[REP2-084] Applicant Response to ExAs 1st Written Questions

[PD-014] Q18.0.6

Barred Routes

Figure 2.1 Site Access Location Plan

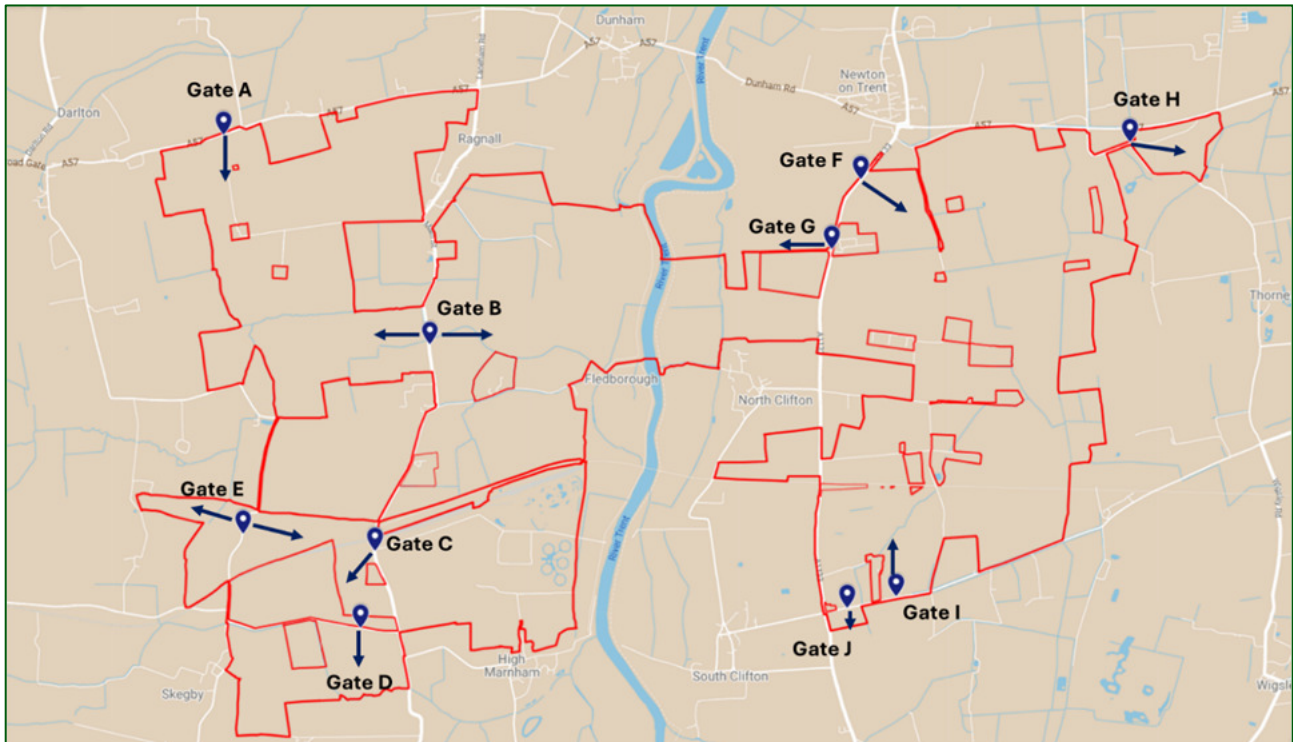
During consultation, myself and others specifically raised the issue of the narrow single-track lanes to the East of the A1133 in North Clifton (Mill Lane, Moor Lane, and Cottage Lane). The Applicant advised these would not be used for construction or site traffic on the basis that they are unsuitable. I note Mill Lane (East) North Clifton is listed and shown as a barred route but Moor Lane, North Clifton is not. The Applicant has previously stated when asked, this single track road would not be used and the access point that was shown previously has been removed as shown within [REP4-026] Figure 2.1 Site Access Location Plan.

Figure 4.2: Barred Route Plan (Inset)

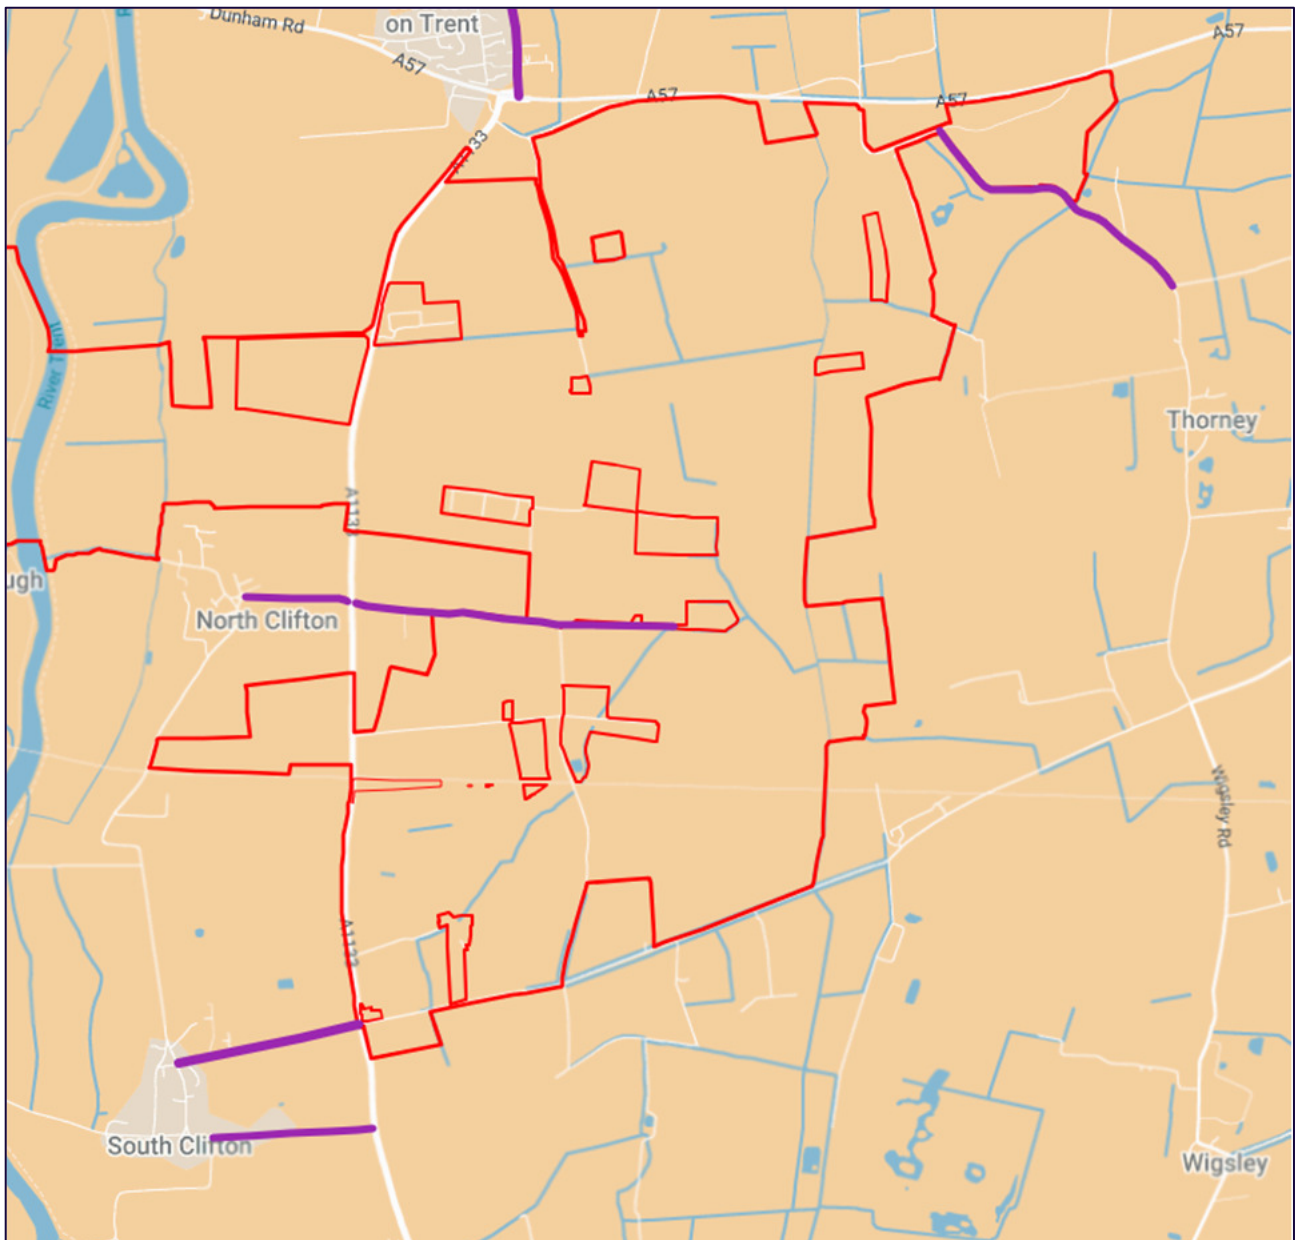
Outline Construction Management Plan [REP4-026] updated October 2025 still contains unclear information in relation to the barred routes, which I raised in a previous submission [REP3-088]. It is noted and appreciated there is a more detailed map for North and South Clifton, however there are still several discrepancies between the roads listed and those shown in Figure 4.2. I also believe some roads have been omitted from the barred routes list which The Applicant has previously discussed with local residents and confirmed would not be used for construction and site traffic.

Within [REP4-026] point 4.2.8, the roads listed are as follows:

- Mill Lane (to the west and east of the A1133)
- Moor Lane (to the west of the A1133)
- High Street (South Clifton), to the west of the A1133

The roads shown in Figure 4.2 are as follows, as stated by their official road signs:

- Mill Lane, North Clifton (to the west and east of the A1133)
- Mill Lane, South Clifton (to the west of the A1133)
- Vicarage Road, South Clifton (to the west of the A1133)

Moor Lane, North Clifton

I would request Moor Lane, North Clifton is listed as a barred route as the Lane is a single track and not suitable for construction and site traffic. The junction where Moor

Lane joins the A1133 is very dangerous, it is on the crest and brow of a hill, depending on the direction you are approaching from, and visibility is very restricted in both directions.
